WEST SUSSEX COUNTY COUNCIL CONSULTATION

TO:	Arun District Council FAO: Andrew Wood
FROM:	WSCC - Highways Authority
DATE:	23 May 2019
LOCATION:	117 Elmer Road Bognor Regis PO22 6LH
SUBJECT:	M/42/19/PL Demolition of existing dwelling & erection of pair of semi-detached chalet dwellings with on-site parking facilities & new vehicular access.
DATE OF SITE VISIT:	
RECOMMENDATION:	More Information
S106 CONTRIBUTION TOTAL:

parking & vehicular access

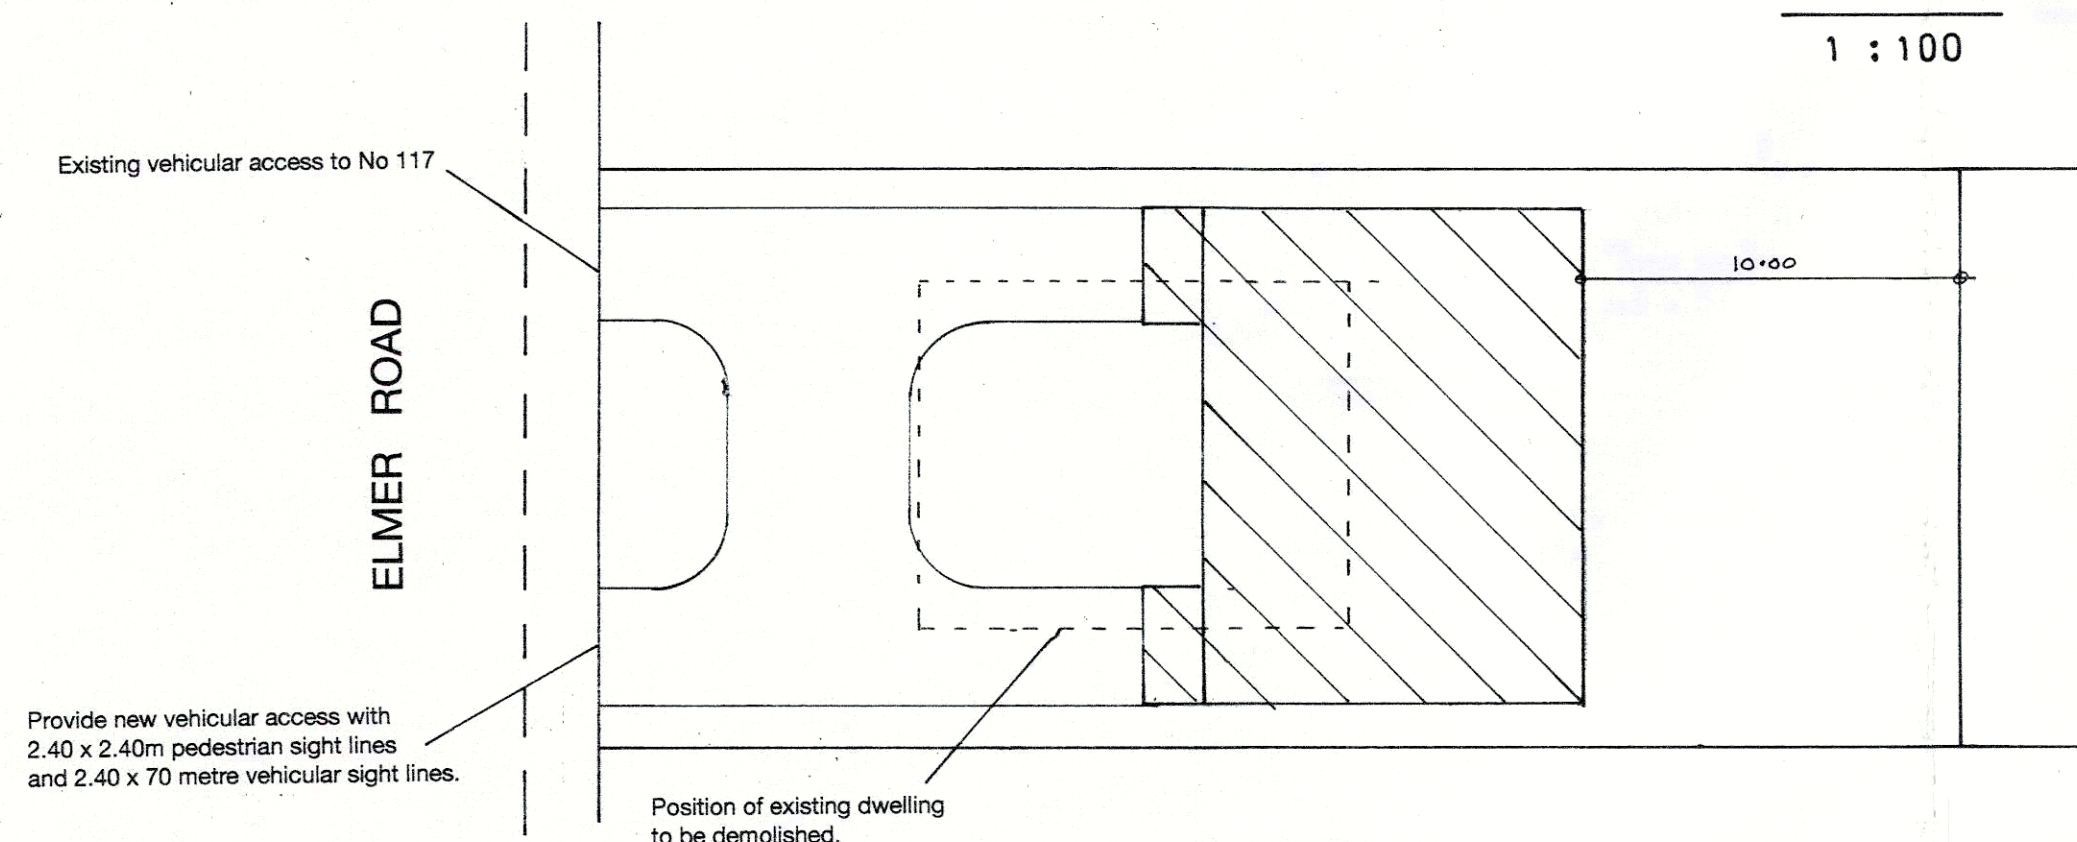
- Cycle Storage Location,
Reason: Sustainability
- Plan detailing Vehicle Cross Over (VCO) dimensions Pedestrian/Vehicular Visibility Splays,
Reason: Highways Safety
- Construction management Statement/Plan,
Reason: Due to the nature of the road we ask that all construction matters are kept onsite. This can be secured via condition.
- Any additional Parking onsite other than the shown Garage's illustrated on a detailed plan.
